Current Zoning: N1-C (Neighborhood 1)
Proposed Zoning: UR-2(CD) (Urban Residential, Conditional)

Approximately 16.36 acres located north of Sledge Road and east of Steele Creek Road.

The petition proposes to redevelop a site in the Steele Creek community currently occupied by four large lot single family detached dwellings with a continuing care community that could include 22 independent living units, 100 skilled nursing beds, and 70 assisted living beds.

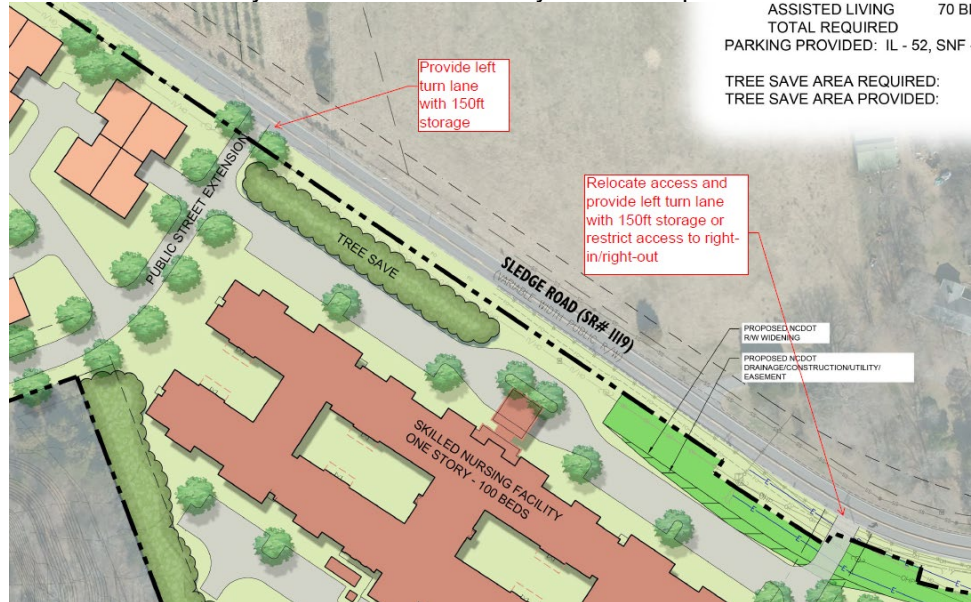
- ~~1. Label the new public streets with CLDSM U-02A (Local Residential Medium Street) standard.~~
ADDRESSED
- ~~2. Remove the following language from conditional note 3.I: "under this Section 3 of the Development Standards".~~ ADDRESSED
